WEST SUSSEX COUNTY COUNCIL CONSULTATION

TO:	Arun District Council FAO: Hebe Smith
FROM:	Highways, WSCC
DATE:	28/04/2026
LOCATION:	10 Longford Road, Bognor Regis, PO21 1AQ
SUBJECT:	BR/59/26/DOC Approval of details reserved by condition under BR/69/24/PL (Appeal Ref: APP/C3810/W/24/3357172) relating to conditions 4- Car Parking, 5- Cycle Parking, 6- Electric Vehicle Charging, 7- Biodiversity Net Gain.
DATE OF SITE VISIT:	N/A
RECOMMENDATION:	Advice

Rev.	Date	Description
Longford Living LTD		
Job Title		
10 Longford Road, Bognor Regis – Planting plan		
Drawing Title		
Existing and Proposed Site Plans		
Date MARCH 2026		
Drawn By RB		
A3		
DRAFT		
Orig. No.		Rev.
7181 - 23 - 4

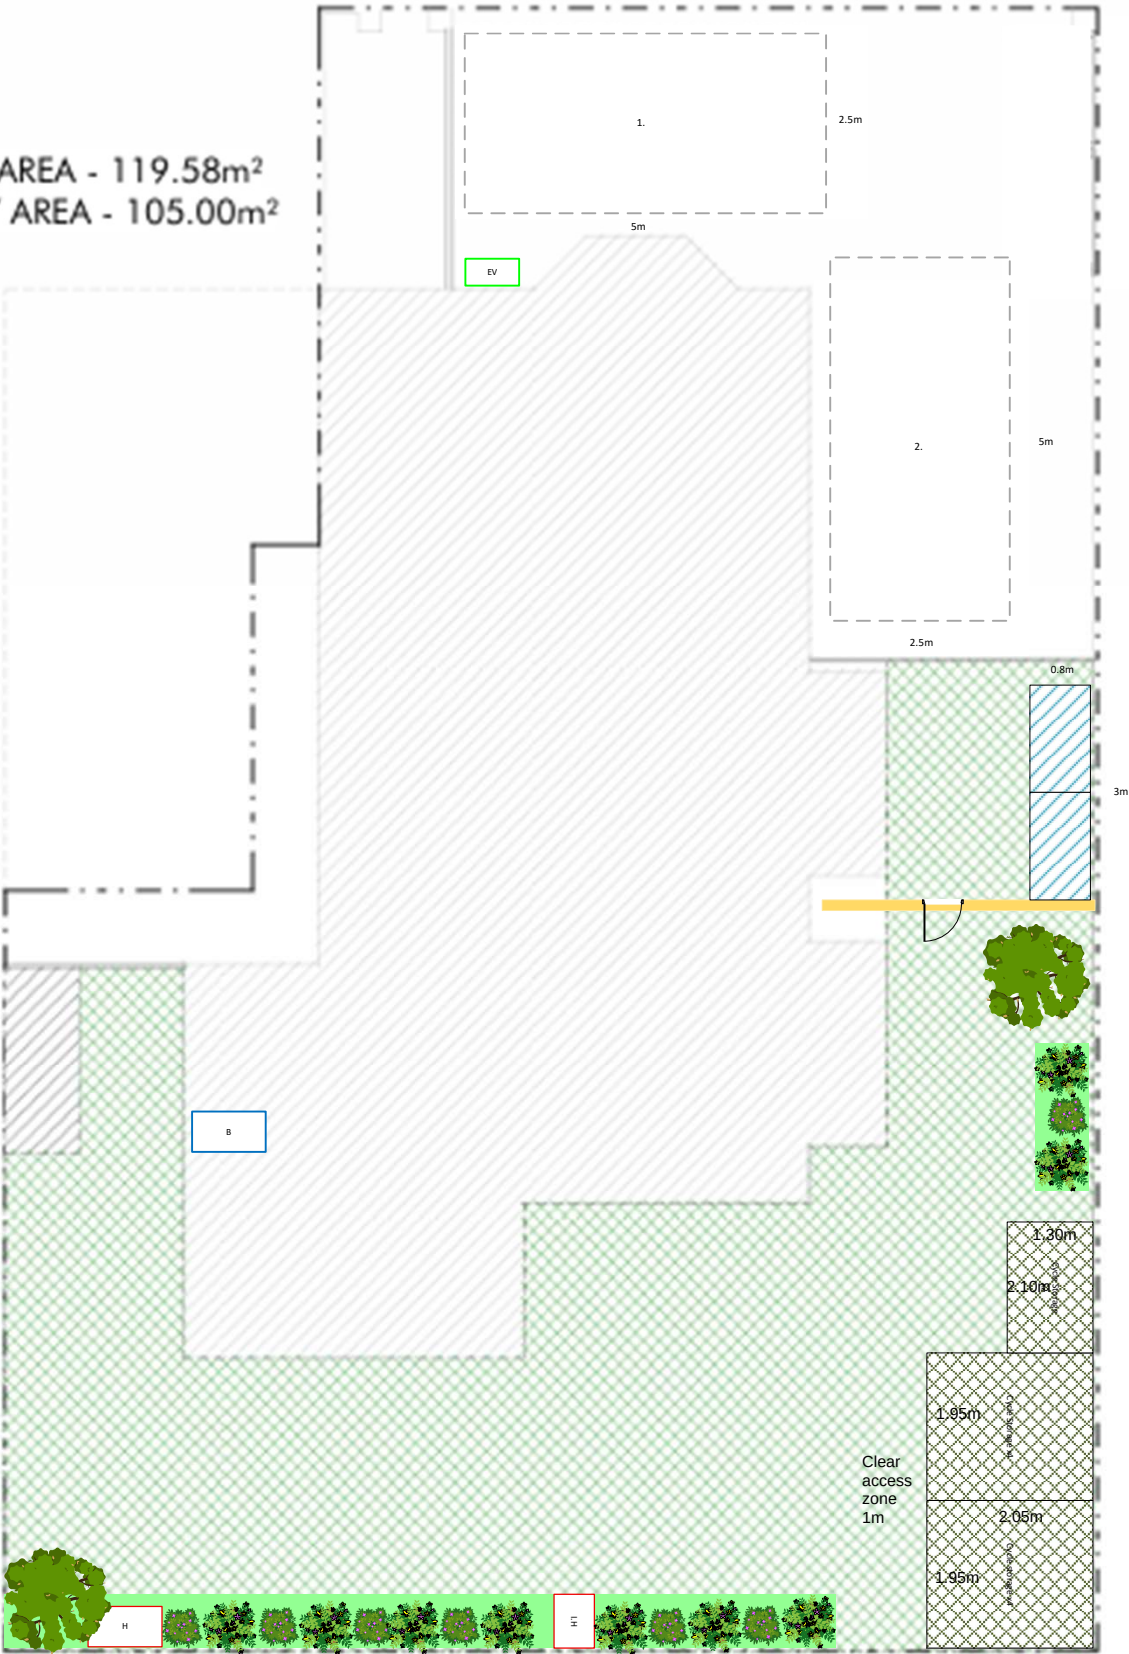
The applicant has submitted a site plan (7181-23-4) demonstrating the two proposed car parking spaces. I note they are labelled as measuring 2.5m x 5m, as stipulated by the wording of the condition. However, a measure of the plans brings out measurements of 2.4m x 4.8m. This would be in accordance with Manual for Streets (MfS) specifications for parking bay dimensions, and I can also appreciate that there is sufficient space to accommodate parking bays of 2.5m x 5m. As such, no concerns would be raised in this regard, and the LHA are satisfied with the details provided in regards to Condition 4.

The applicant has submitted a site plan (7181-23-4) demonstrating the location of ten cycle parking spaces provided to the rear of the site. Each unit will be covered, lockable and accessible. As such, the LHA are satisfied with the details provided in regards to Condition 5.

The applicant has submitted a site plan (7181-23-4) demonstrating the provision of one EV charging point to serve the proposed parking area. The LHA are satisfied with the details provided in regards to Condition 6.
